Our Ref: Y/105/21/NMA

Non material amendment following the grant of Y/82/20/RES for amendments to the proposed site layout.

Land to the south of Ford Lane and East of North End Road Yapton BN18 0DS

Title:
 OCCUPANCY PLAN

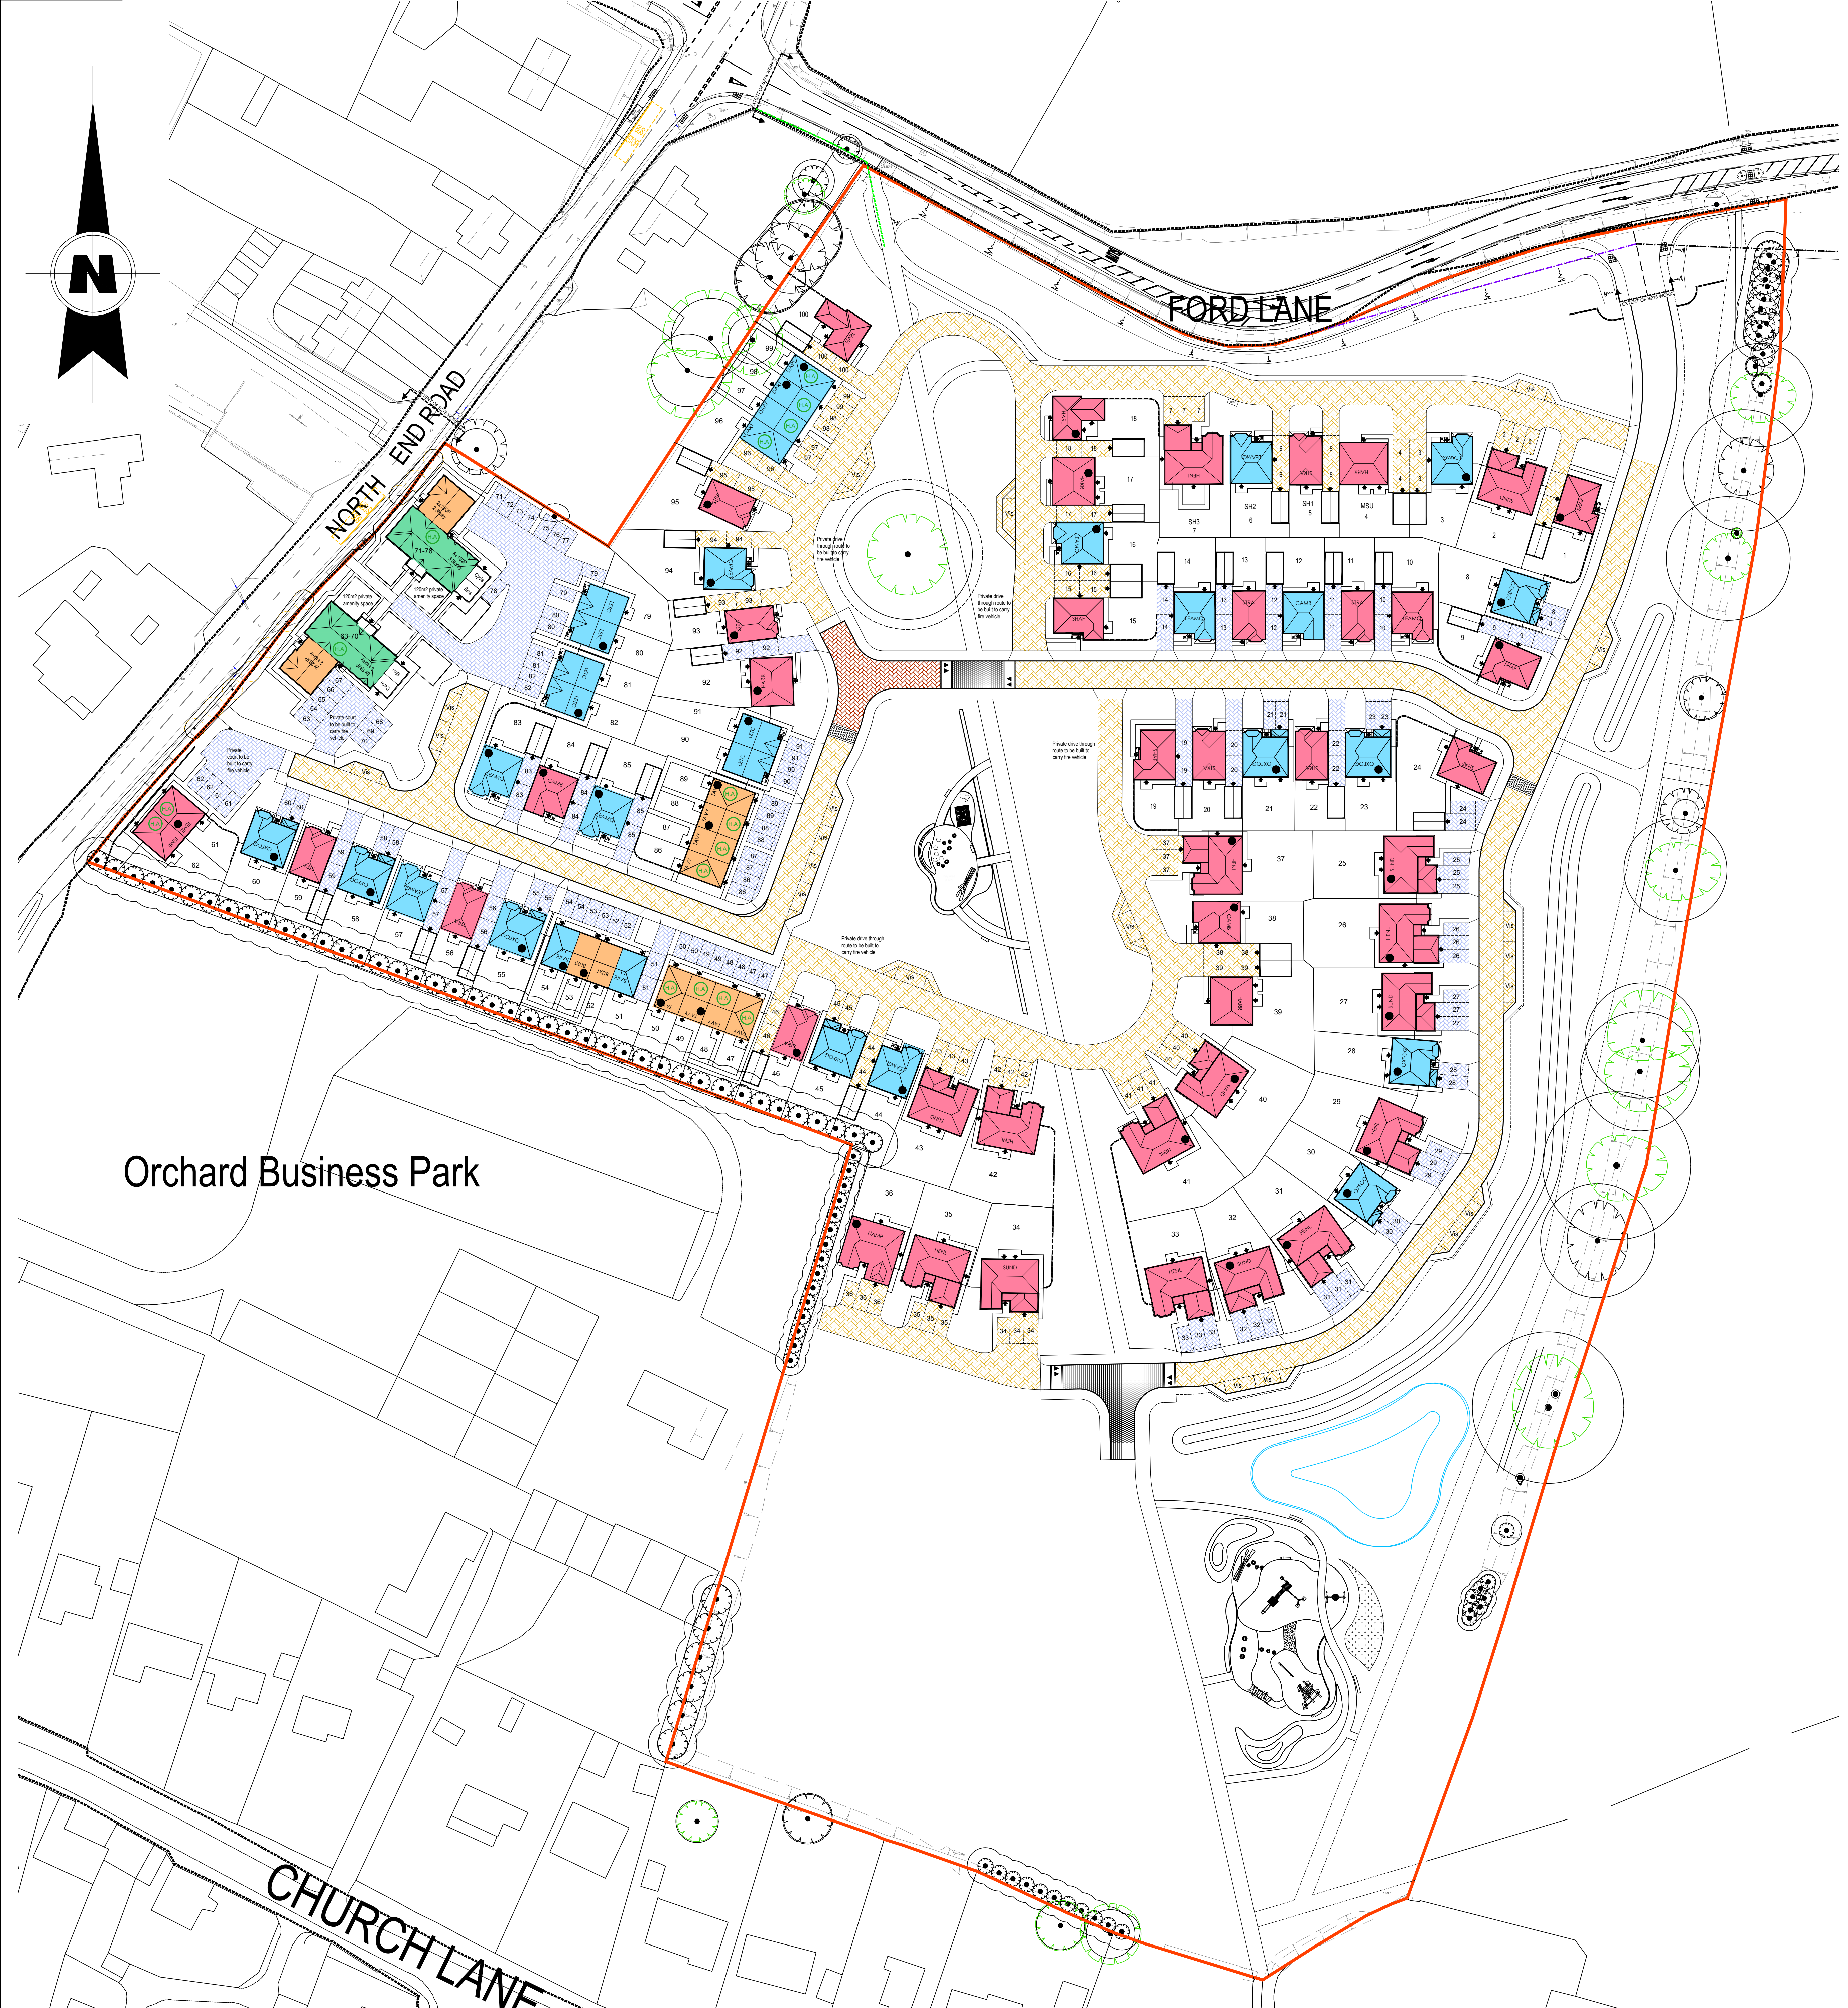
I refer to your recent application for a Non Material Minor Amendment. I note that you propose to make alterations to increase the width of the footways and cycleways to 3.0 metres wide in accordance with Y/131/20/DOC; to re-locate the parking spaces serving Plots 79-82 to ensure adequate health and safety provisions for electric vehicle charging points; to remove the approved pumping station as it is no longer required and the subsequent re-location of the turning head near Plot 34; to re-locate the play area and the surface water drainage features to the eastern side of the footpath in the southern area of open space; to alter the house types at Plots 34-36; to re-site Plots 29-30 and Plots 40-41 to enable clearance to a private drain; and to amend the materials on a number of dwellings.

Notwithstanding this, the proposed amendments to increase the width of the footways and cycleways to 3.0 metres wide; to re-locate the parking spaces serving Plots 79-82; to remove the approved pumping station; to alter the house types at Plots 34-36; to re-site Plots 29-30 and Plots 40-41; and amend the materials on a number of dwellings would constitute Minor Non-Material Amendments to Reserved Matters approval (Y/82/20/RES) as they constitute amendments that do not have a material impact on neighbouring residents and would not warrant re-consultation either of neighbours, council departments or statutory bodies; but a separate Section 96A application would be required to be submitted for approval.

Drawing Title
Sections through Infiltration Basin

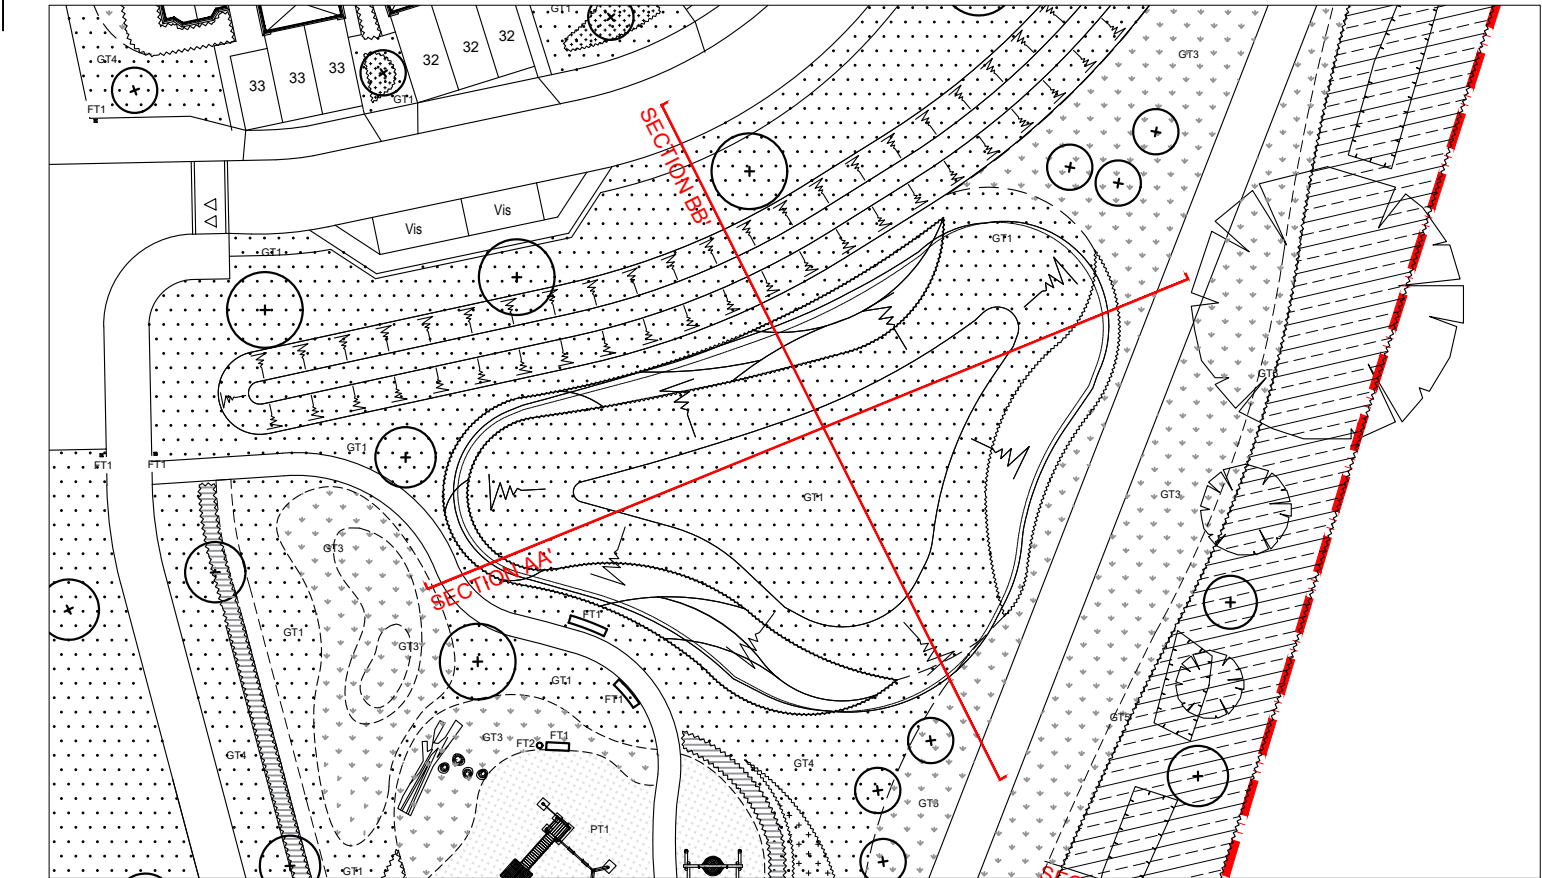
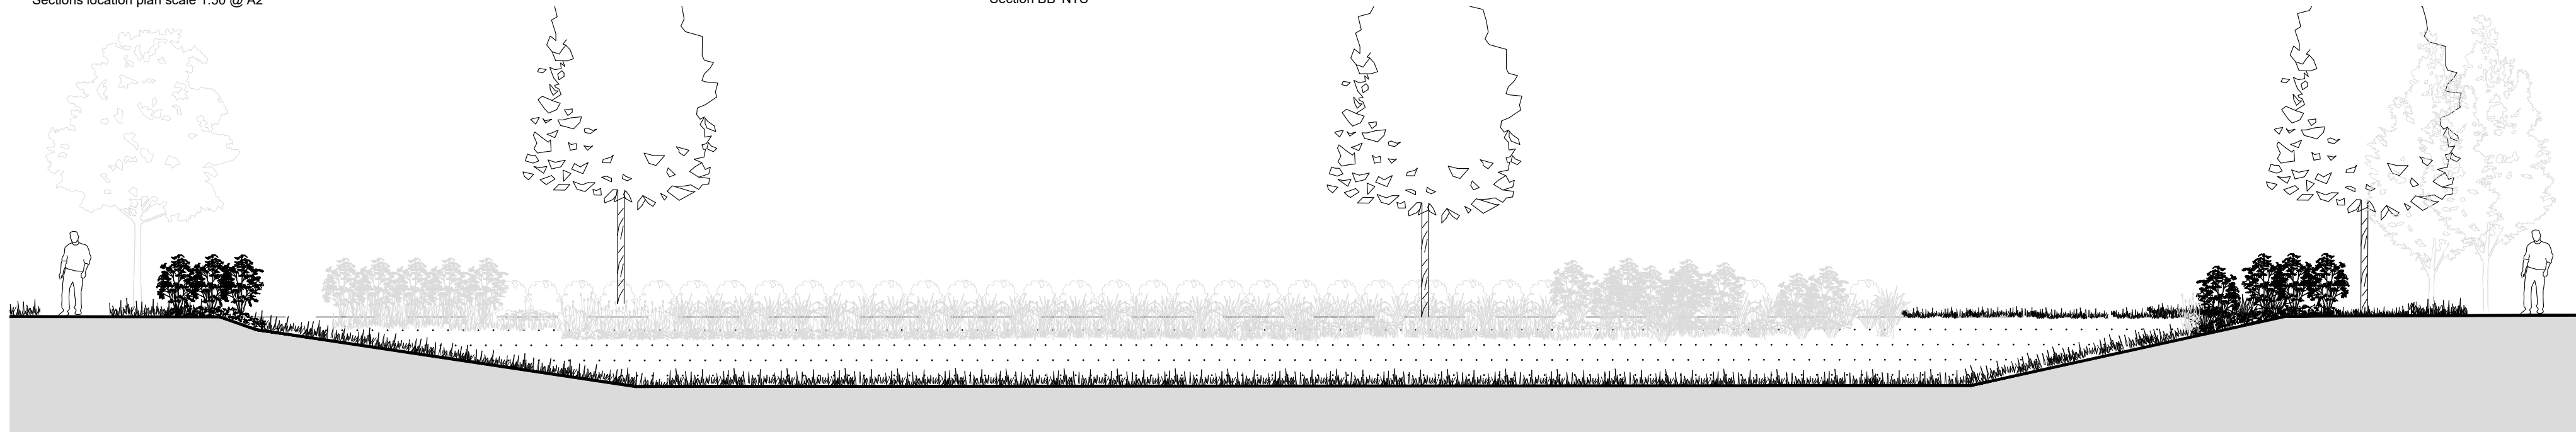
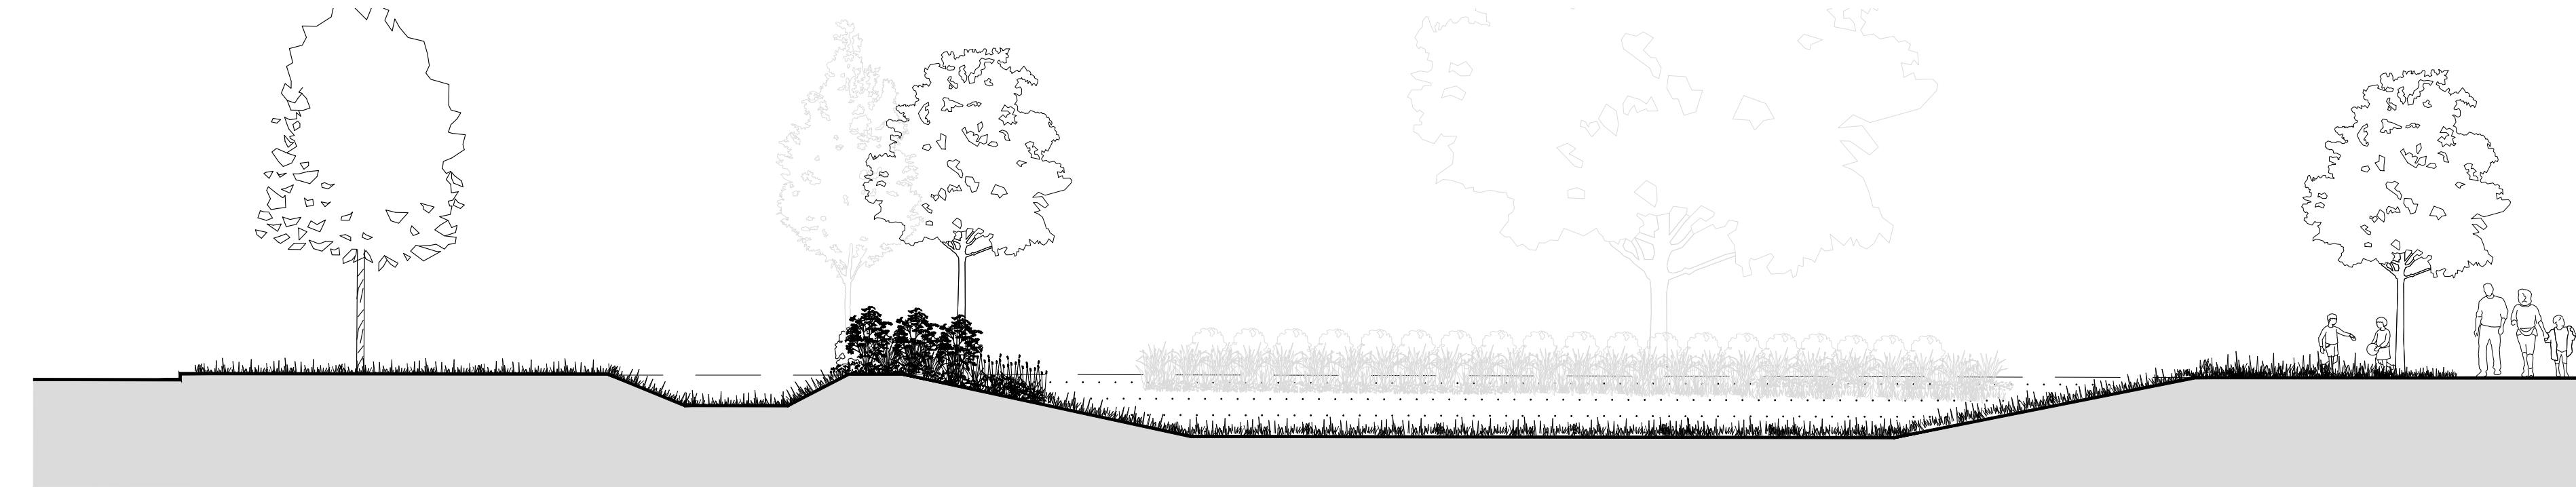
The reason that this proposal has not been accepted as a Non-Material Amendment is because the re-location of the surface water drainage features to the eastern side of the footpath in the southern area of open space would have a material effect upon the approved

layout of the residential development and would require changes to the approved drainage strategy, which would result in the submission of a separate discharge of condition application. The re-location of the play area to the eastern side of the footpath in the southern area of open space would have a material effect upon the approved layout of the residential development in terms of the outlook from Plots 32 and 33; and the re-siting of the turning head near Plot 34 would compromise the visual appearance of the footway/cycleway and would compromise the safety of users of the footway/cycleway.
